State Significant Development Application Number SSD-10300.
Coffs Harbour Cultural and Civic Space.

I object to this proposal and desire and request that a public hearing be held.

GORDON ST ELEVATION

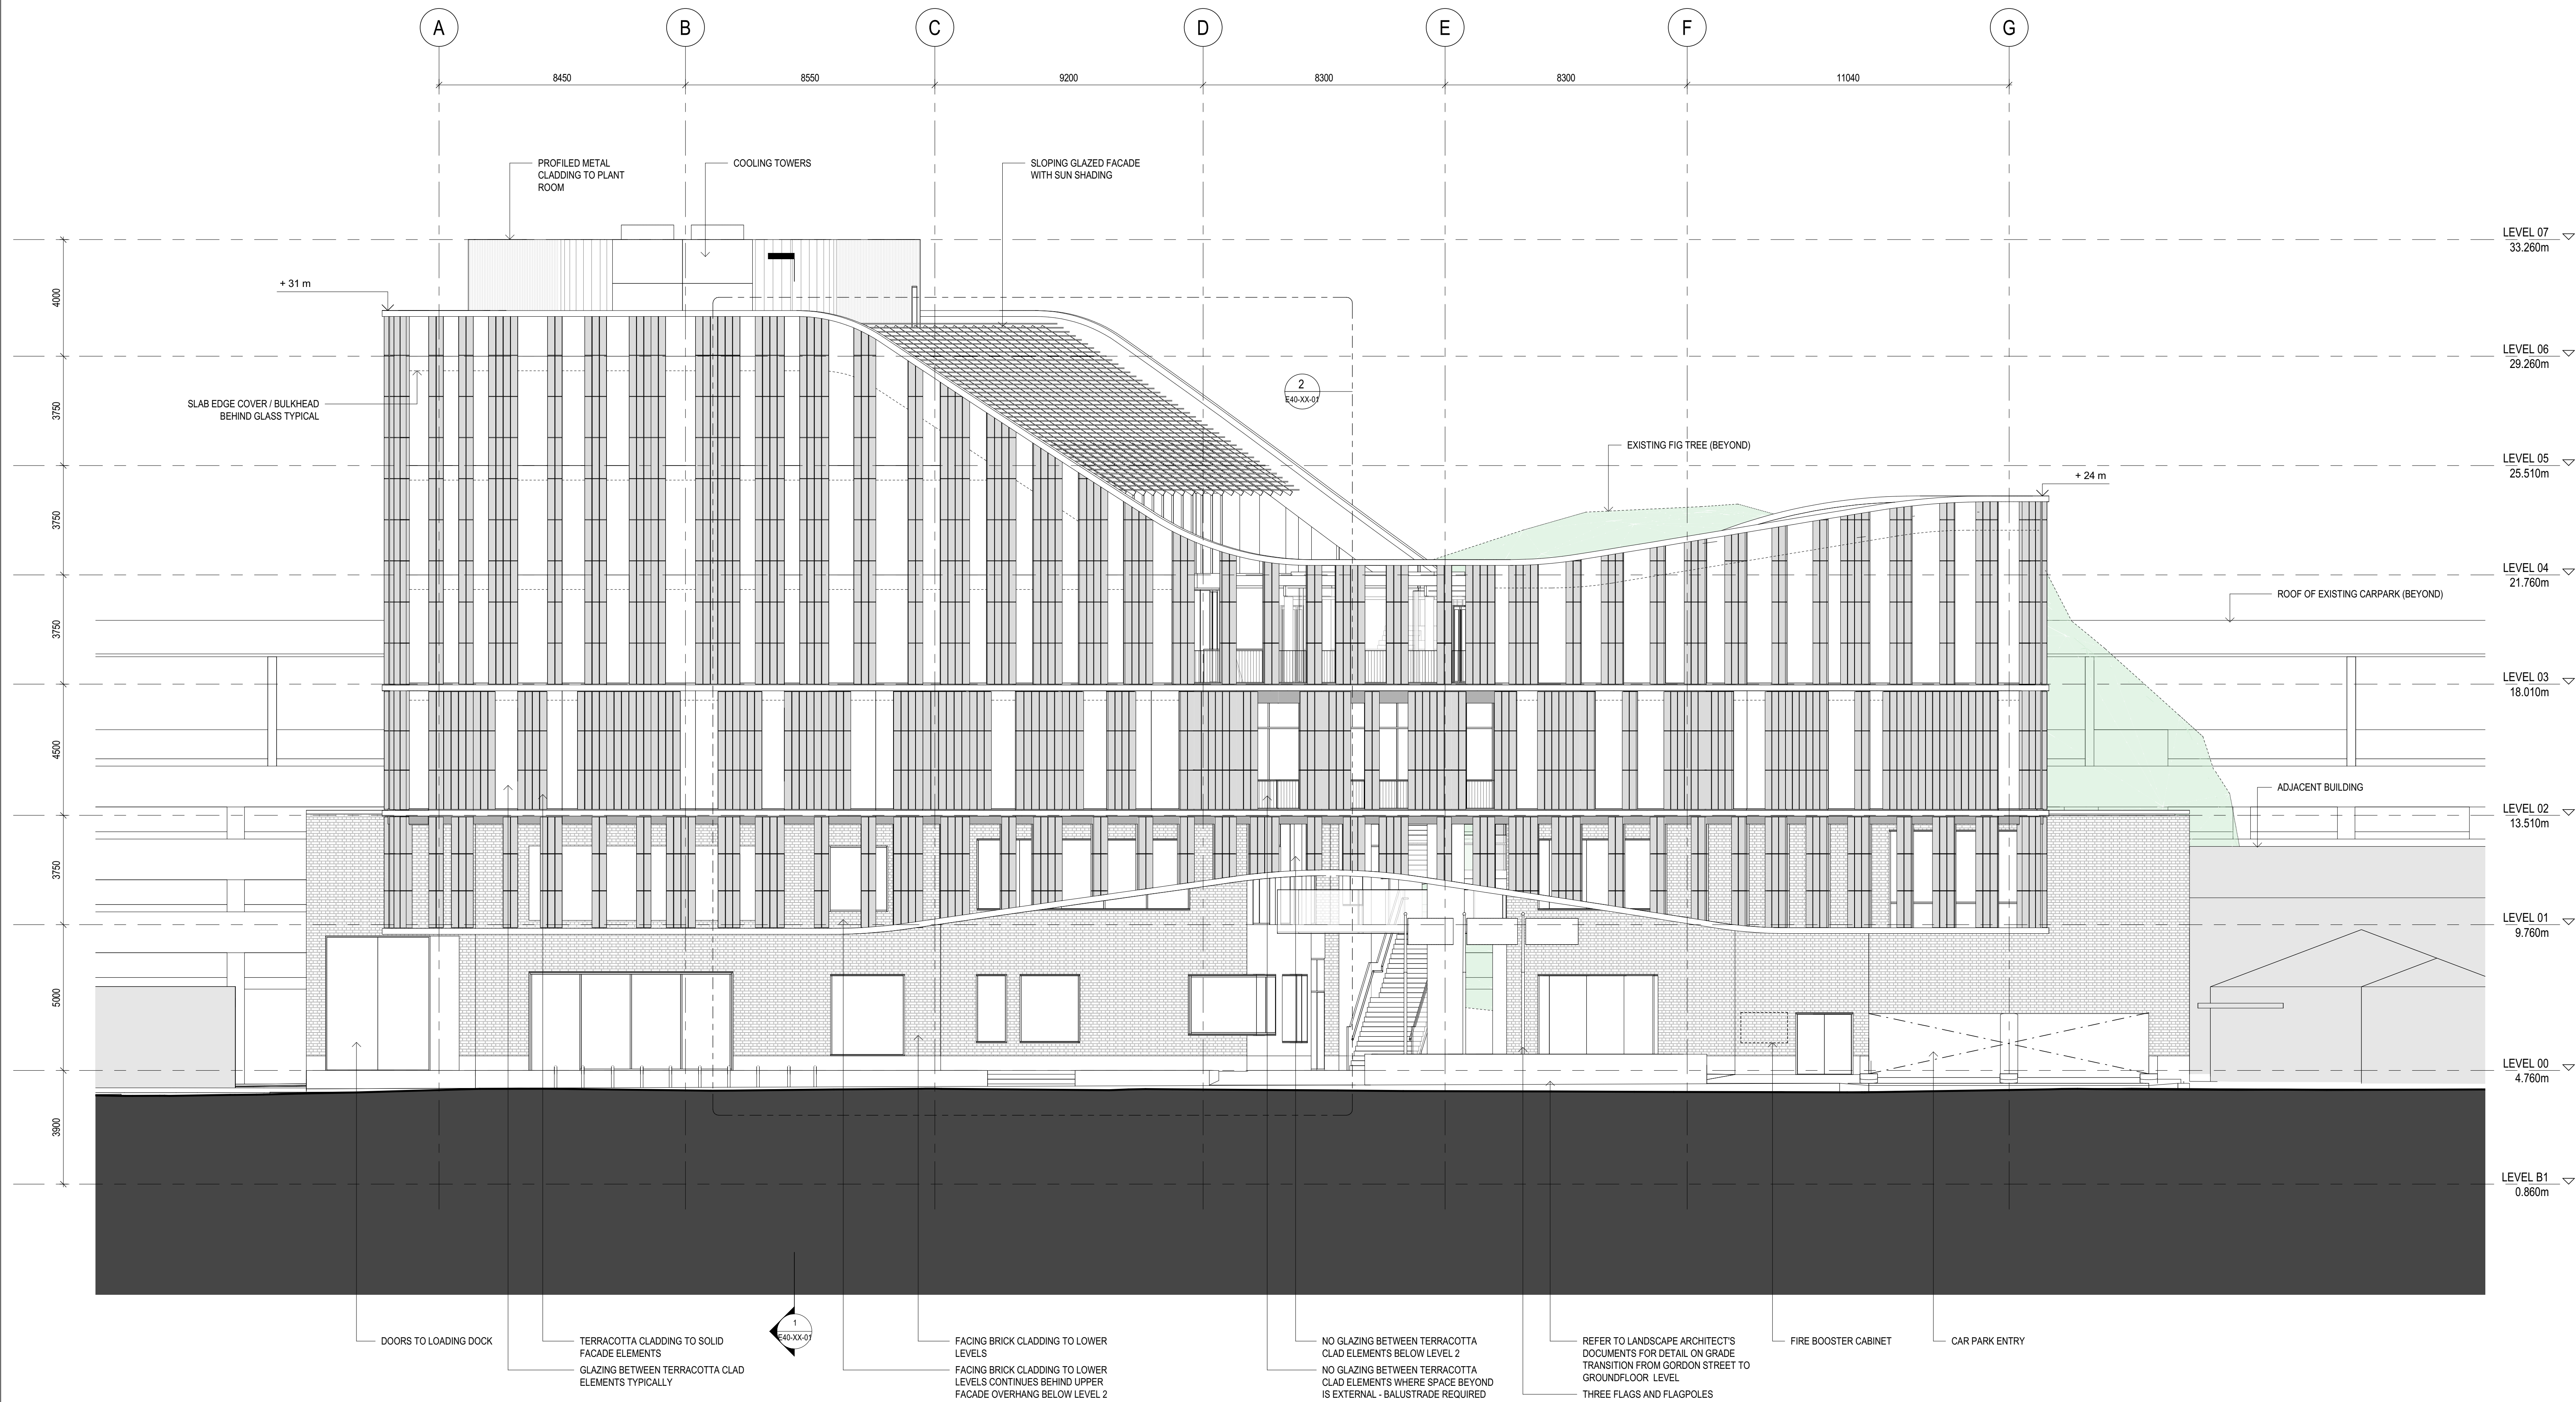
10. It conflicts with the streetscape in Gordon Street in that the proposed building is outside the context of this street having regard to the scale, existing street setbacks, design and general form of the adjoining buildings.

SECTION N-S

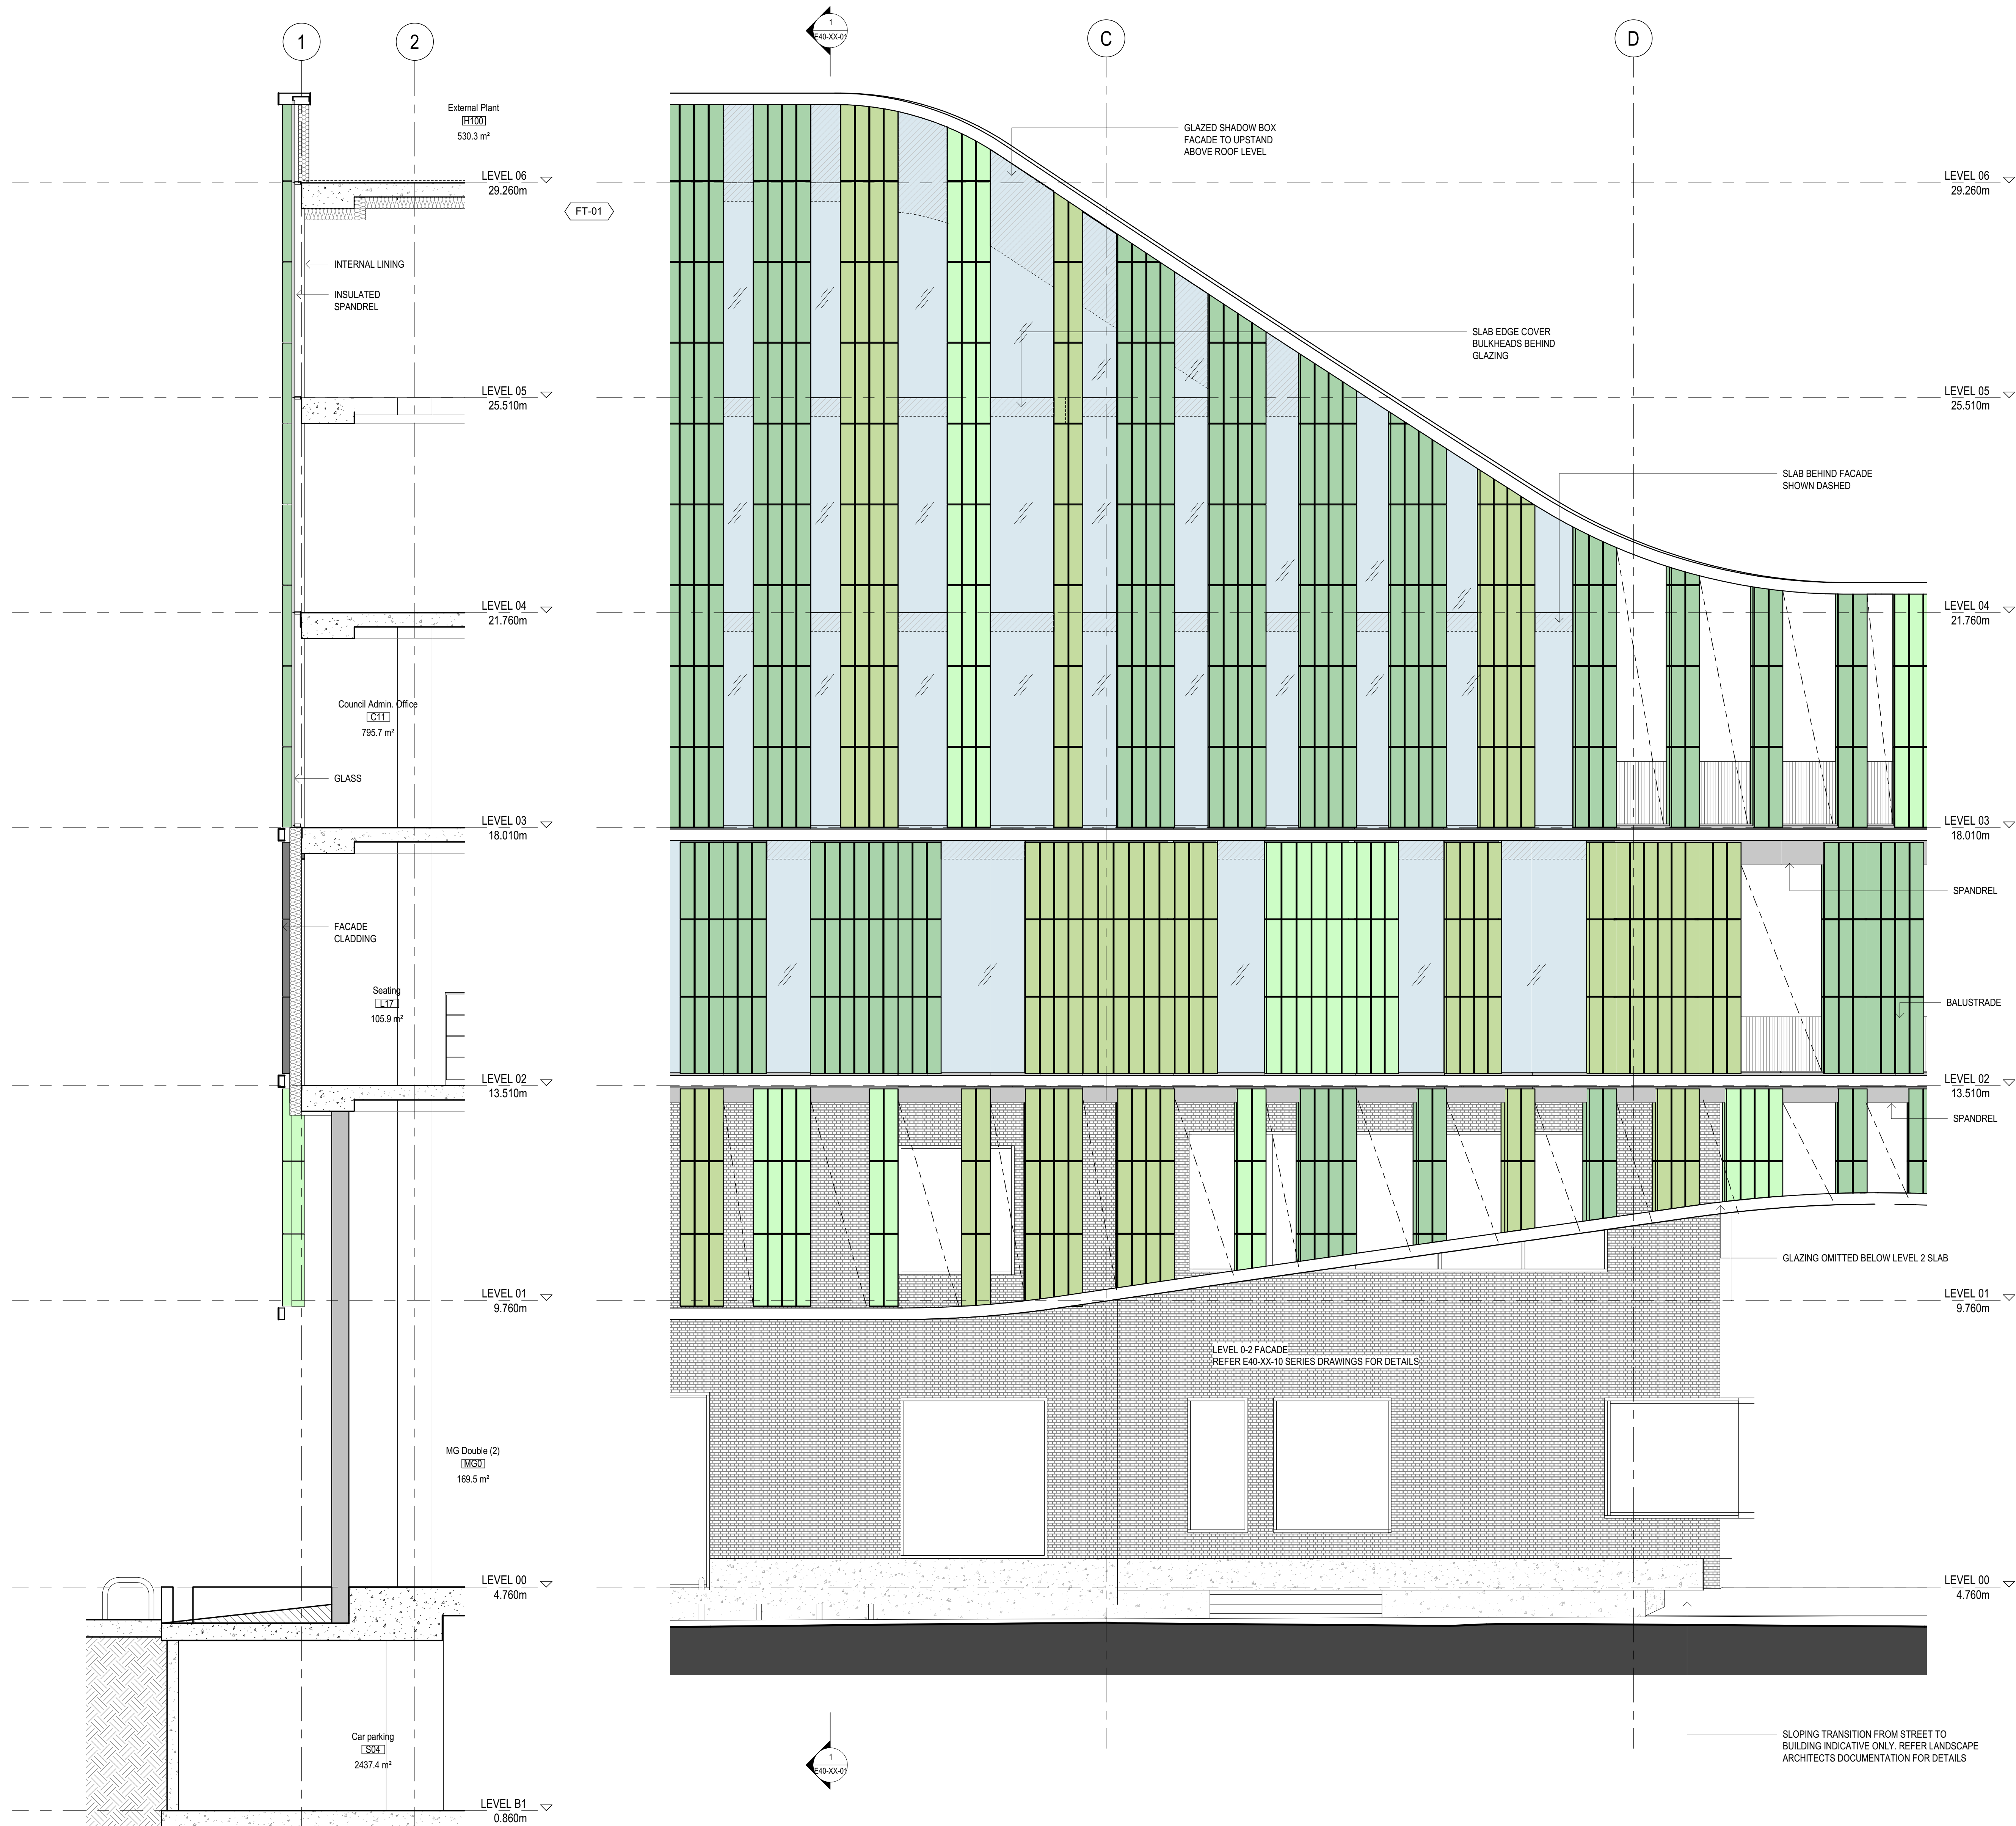
13. It exceeds the height limit of 28 m. set down by Council and an exception is not justified.
